Please ask for: Mrs D Johnson
Email: daun.johnson@arun.gov.uk
Telephone: 01903 737762
Our Ref: LU/124/21/PL
Your Ref:
Date: 20th April 2021

Application for Planning Permission

Development: Change of use from C2 Residential Institution to HMO (Sui Generis). This site may affect the setting of listed buildings & affects the character & appearance of the East Street, Littlehampton Conservation Area.
Location: 18-22 East Street Littlehampton BN17 6AW

Drawing Title
Existing Floor Plans and Elevations (18-20)

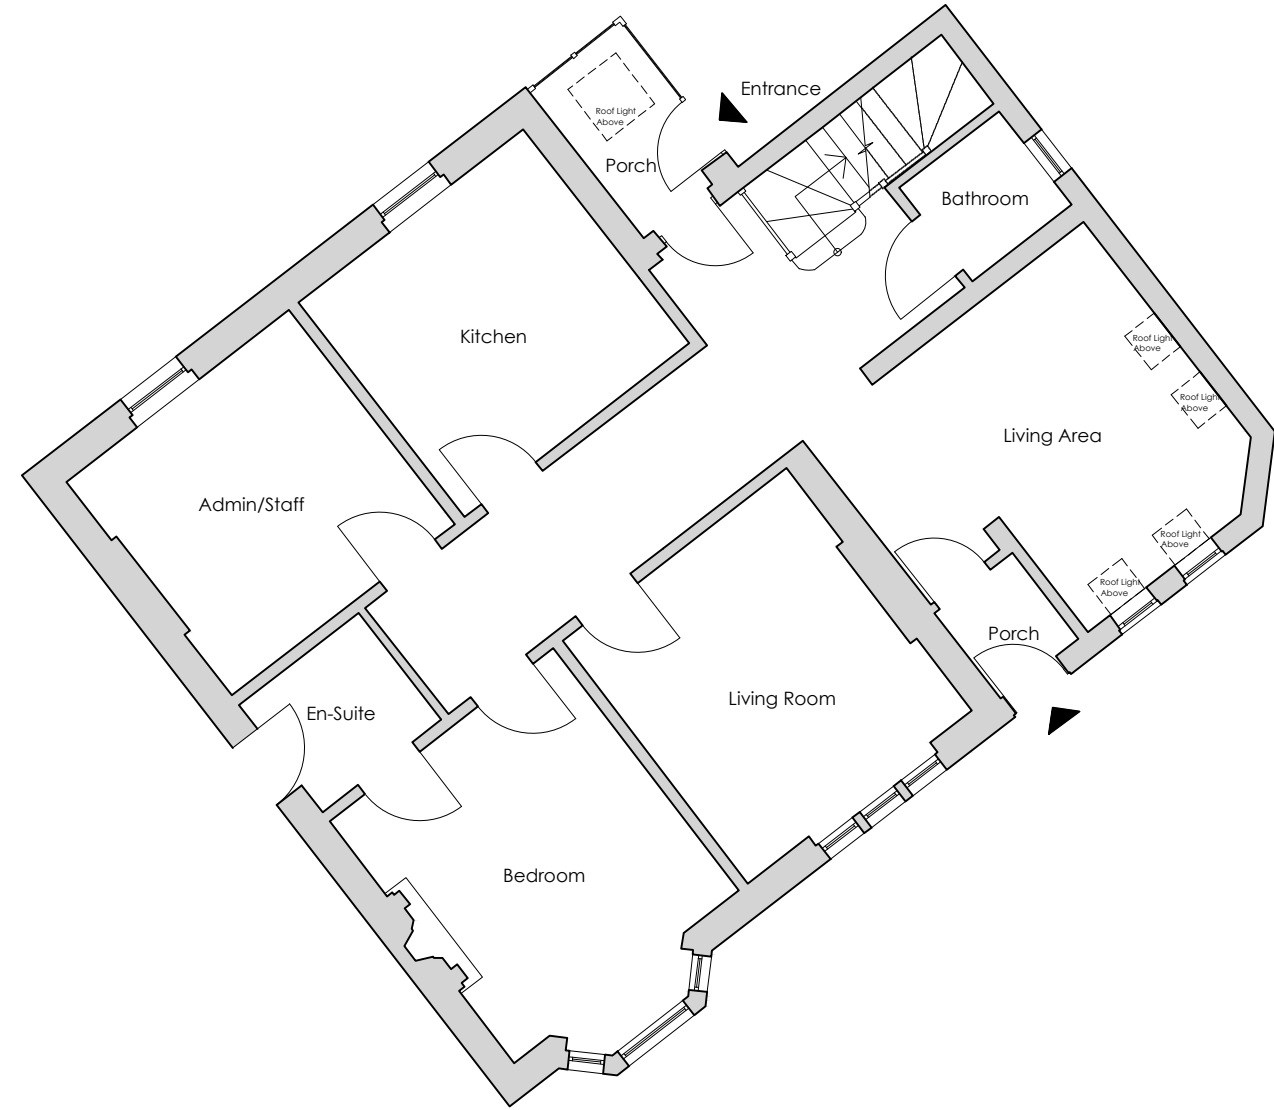
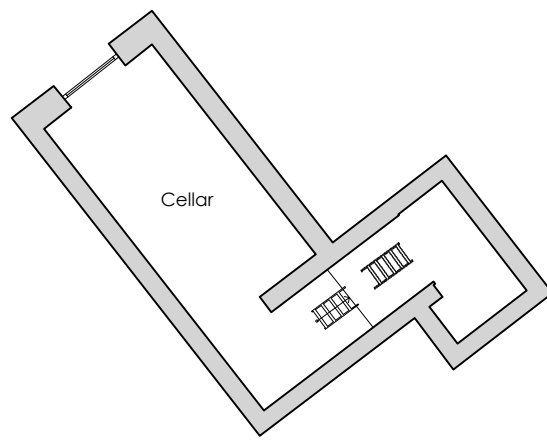
The existing and proposed floor plans and West elevation on 18-20 East Street do not accord. Please amend accordingly.
